CITY OF PORTLAND, MAINE
Department of Building Inspection

Certificate of Occupancy

25 Cottage Street

SINGLE FAMILY
R-3, Type 5B
IRC2003

1 New First Floor Plan
1/4" = 1'-0"

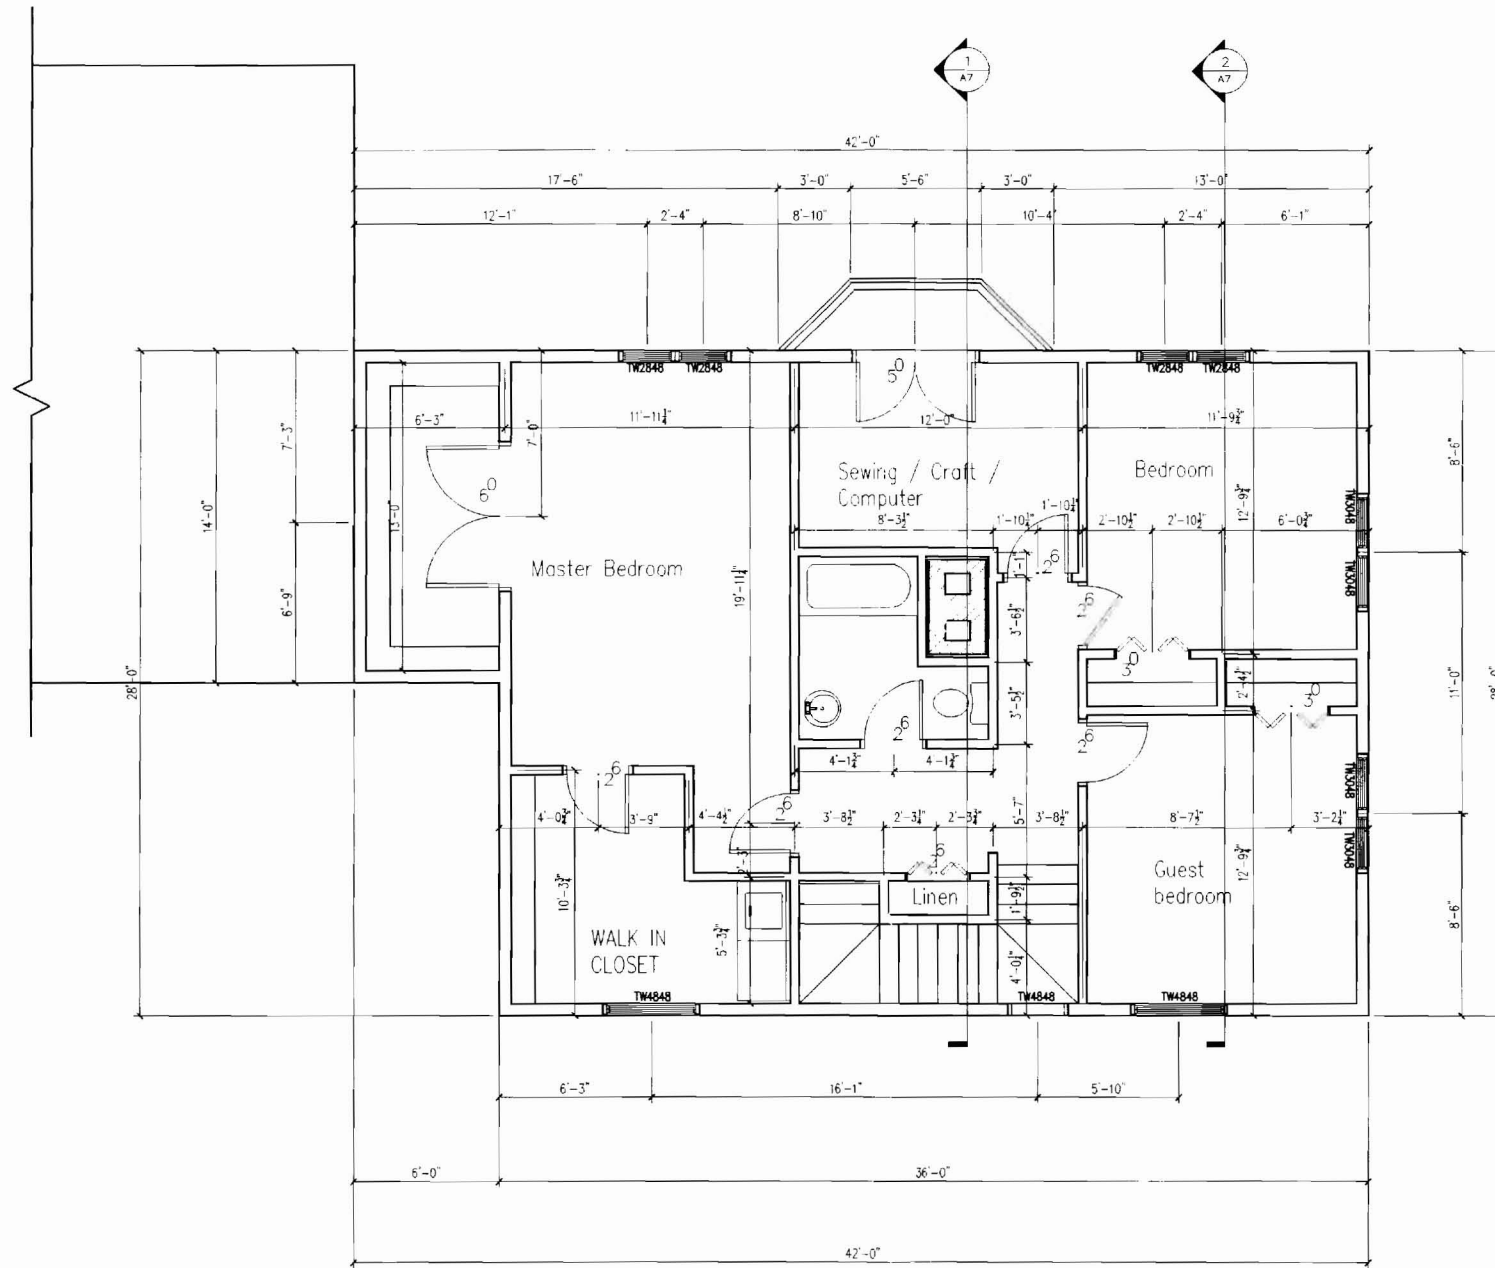
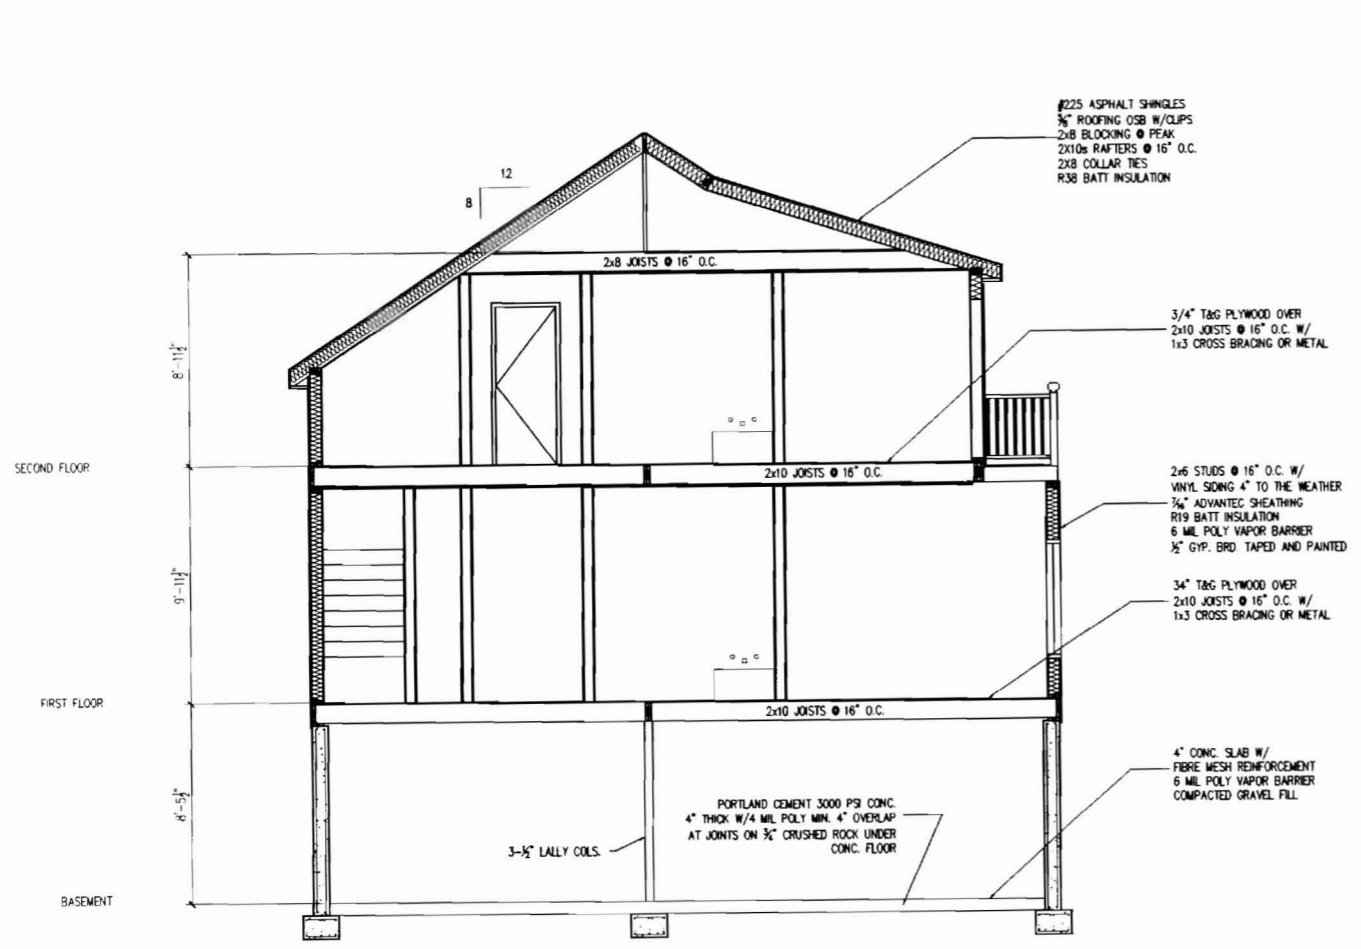
1/7/3/08 - Final for Coy 0 - ① light fixtures not in -
② panel box needs to be marked ③ Rail system not on rear porch
④ Chimney disclaimer statement not done (gave a copy to Phil McCall)
⑤ Phil's memo not there - ⑥ one bathroom on 2nd floor is to
remain plumbed but not complete. ⑦ Switch plate covers
needed throughout.
